Ducy Stables and Riding Academy, PPR-19-027

Please accept the following comments from El Paso County Public Health regarding the project referenced above:

PCD FILE Nos PPR-19-027 and AL 19-016

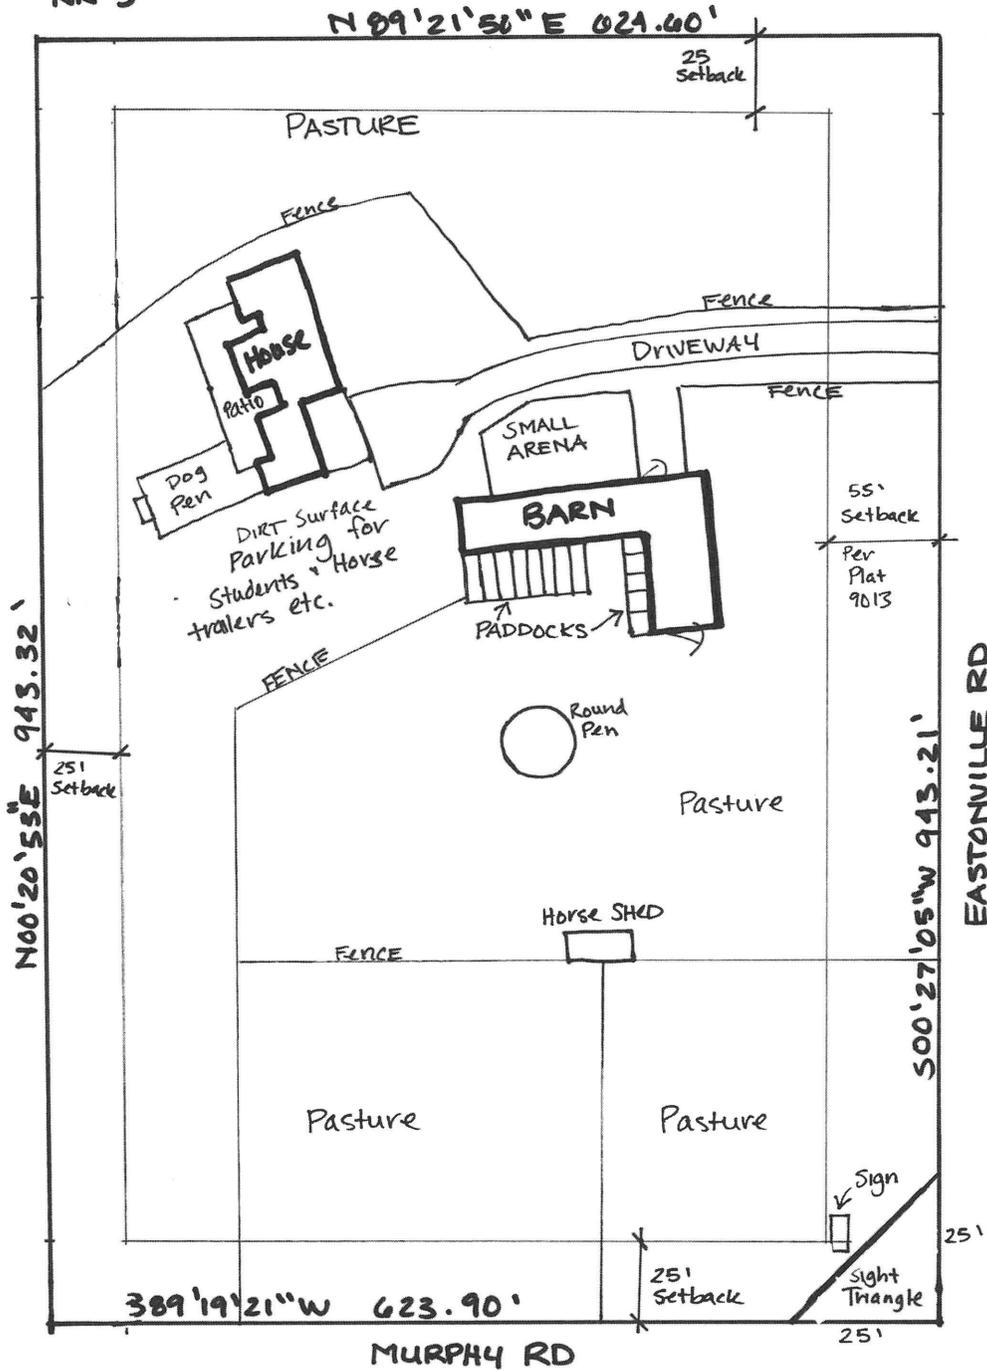
- A record of an approved, permitted on-site wastewater treatment system (OWTS) for this property indicates the original OWTS was installed and approved in 1997. In 2003, an addition to the soil treatment area and a new service line to a barn was installed and the OWTS was approved for a 5-bedrooms. The OWTS component locations are on file at El Paso County Public Health under Tax Schedule Number (TSN) 4132004024.

- If the commercial stable operation is only for boarding horses, then the use of the restroom in the barn for those boarding their horses would not be necessary. Impact to the existing OWTS with only occasional use would be insignificant.

- Please assure all components of the OWTS are located and protected from vehicular traffic, horses and other means of compaction. A secondary site on the property must also be preserved for the possibility of a repair, addition, or replacement of the existing soil treatment area. Fencing is preferred but other area barrier methods accomplishing the same goal are acceptable. This requirement is only for the protection of the system functionality, the owners investment and prolonged life of the soil treatment area.
